Recommendation Report for Planning Permission for Works or Extension to a Dwelling

REF NO: FG/197/21/HH

LOCATION: 12 Clover Lane
Ferring
BN12 5LZ

PROPOSAL: Erection of single storey front and rear extension following the demolition of garage.

Client's Name		Drawing Title		Drawn	Checked	Date	Rev		Date	Revision Details		Dr	Ch
Mr D C Marr		Existing & Proposed Ground Floor Plan		cb	cb	22.10.21							
Job Title		Scale		Job No		Drawing No		Rev					
Clover Lane		1:100 @ A3		CLF		100							
Ferring

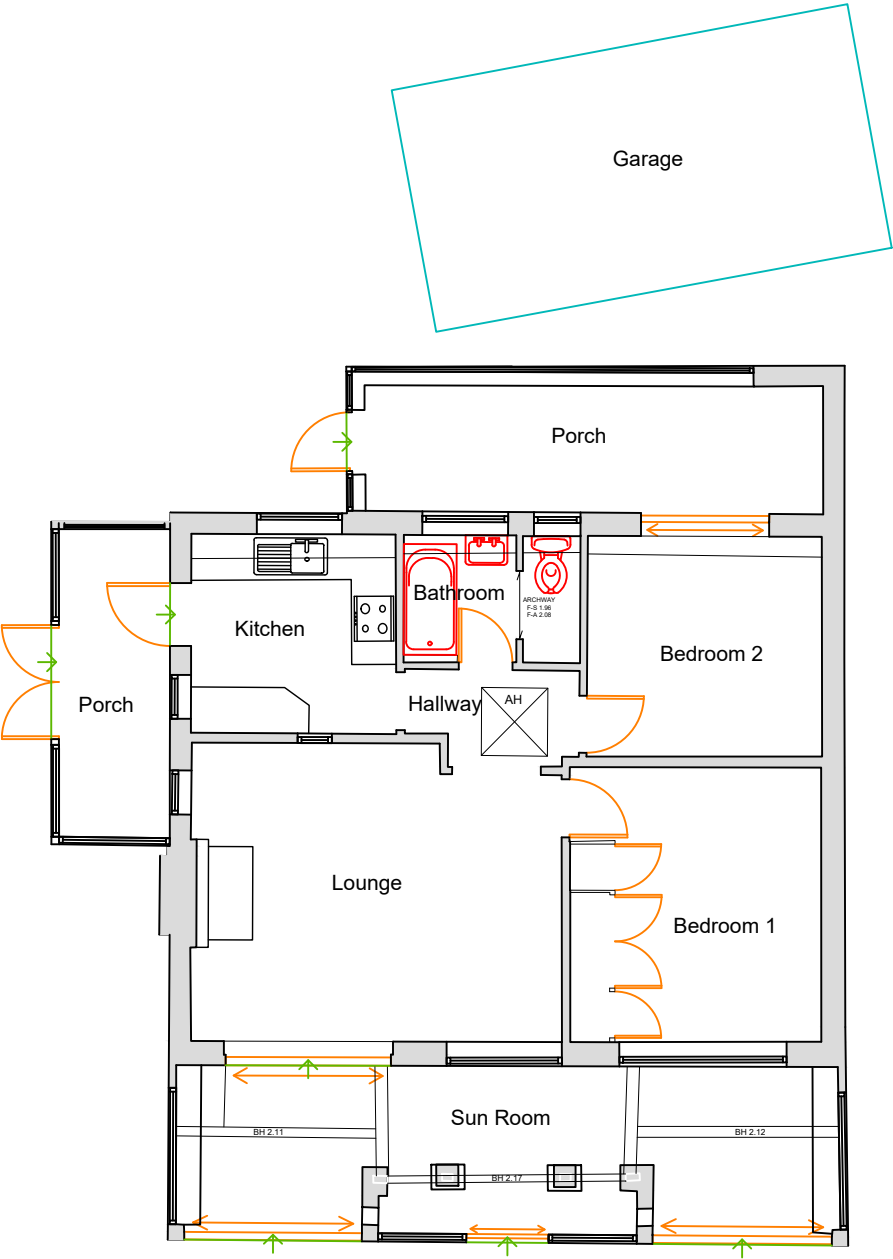
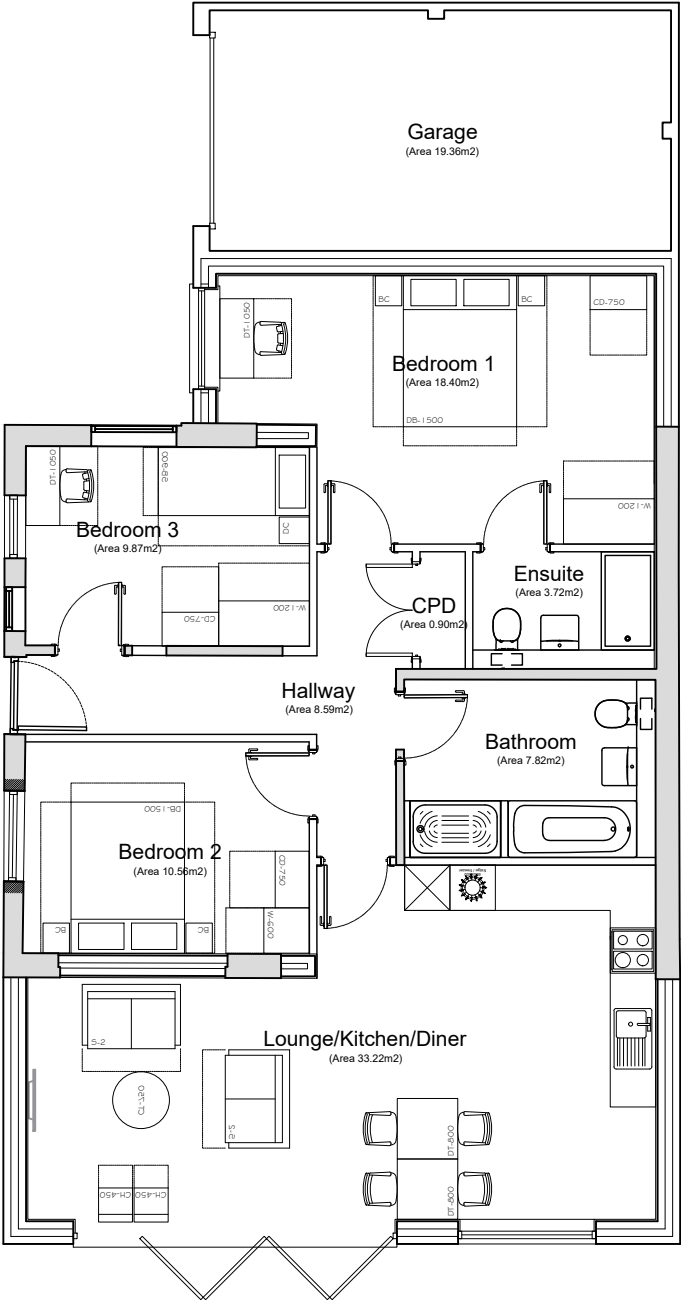
The dwelling will be extended forward by 1.3 metres and the roof will be enlarged. The roof will be extended to the rear by 2.04 metres. An attached garage will be added to the rear of the building replacing an existing detached garage. The rear enlargement will not add more than 3.63 metres to the building in total.

It is considered that the siting, scale and design of the proposed extensions are acceptable and as such they would be subservient and well integrated additions as they would be parallel in roof slope to the existing roof and the flat roofed garage would be behind the house.
